Subject: WA/68/21/PL

I wish to register my objection to the planning proposal WA/68/21/PL for the following reasons.....

Prior to renewing the application WA/63/21/PL Vistry Homes were requested to re-submit plans for the whole site to include the **extra 30 dwellings** they wish to add making a total of **205** (maximum density of housing allowed) as all theories to date for traffic increase never mention this figure surely all calculations are flawed.

Drawing Title:
PROPOSED ALTERNATIVE ACCESS

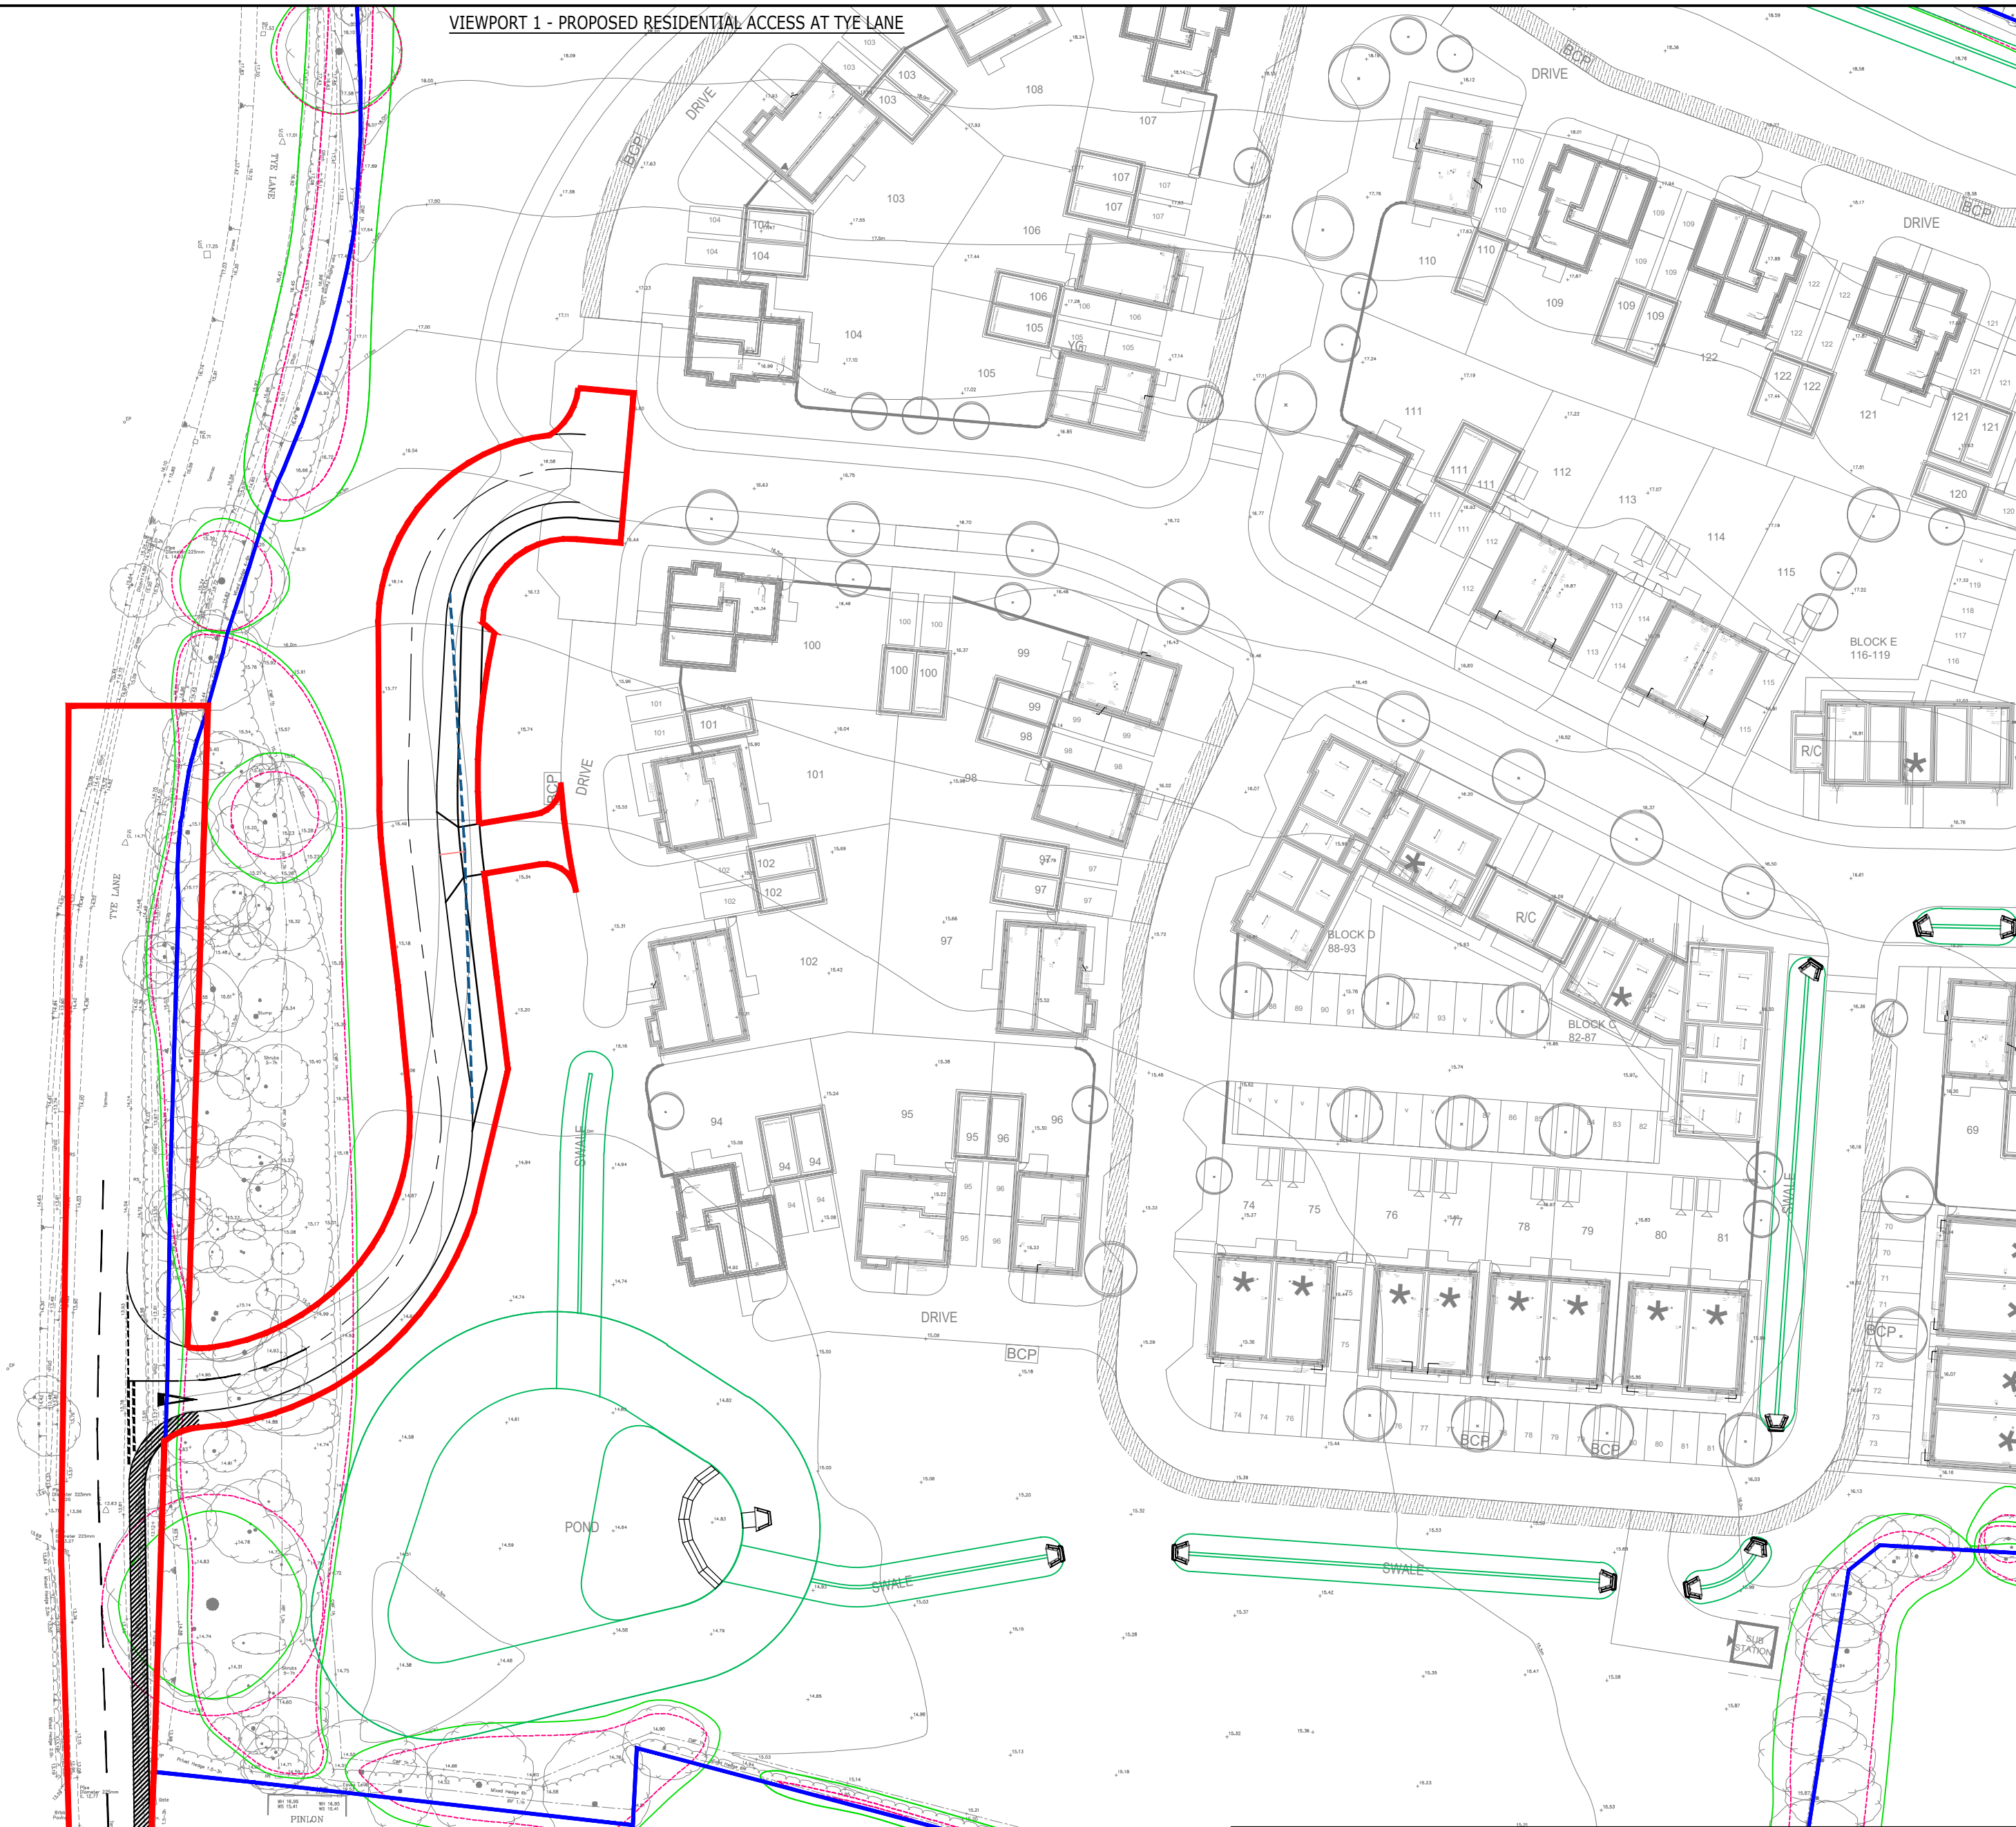
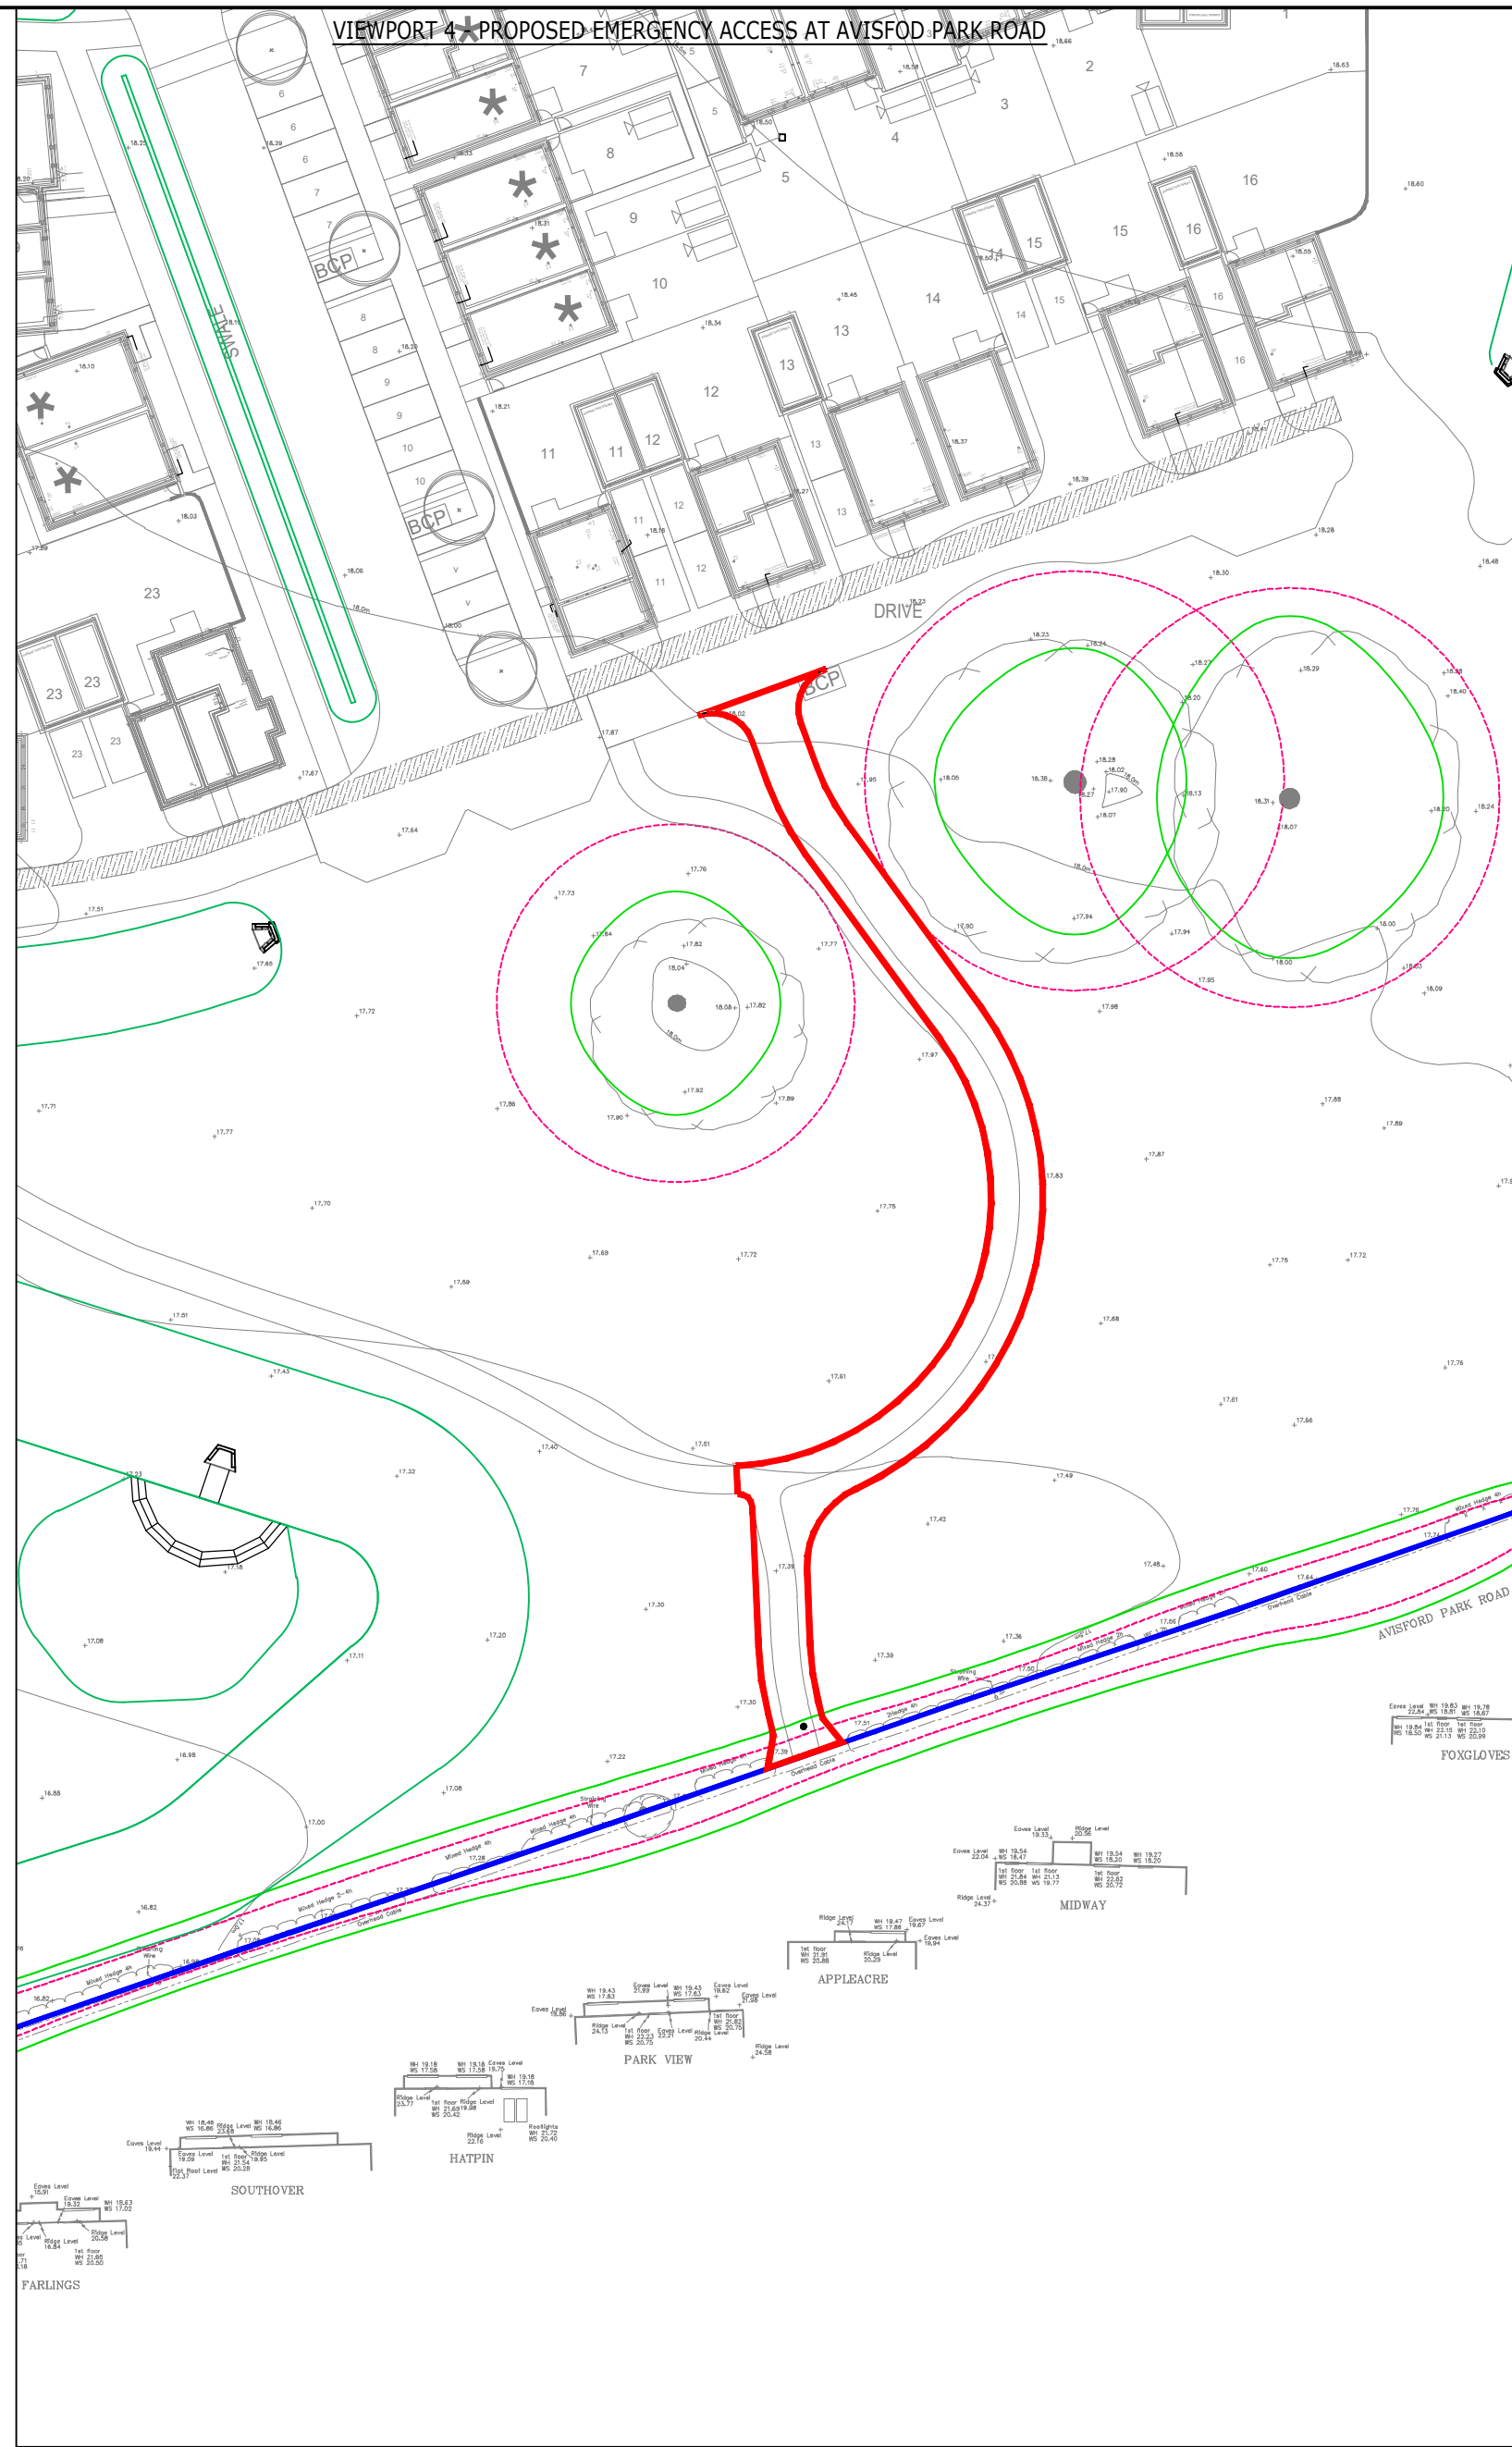
A single access via Yapton Lane is the only answer, there is no necessity for access into Tye Lane or Avisford Park Road for any traffic, even emergency access.

The suggested alterations to remove grass verges, alter or fence ditches, remove the established treeline, create footpaths overriding residents legal parking space and to widen and straighten Tye Lane at both ends for their own convenience contravenes all aspects of the Neighbourhood Plan, ALP, SDPP and the NPF regarding maintenance of the rural aspect of the village.
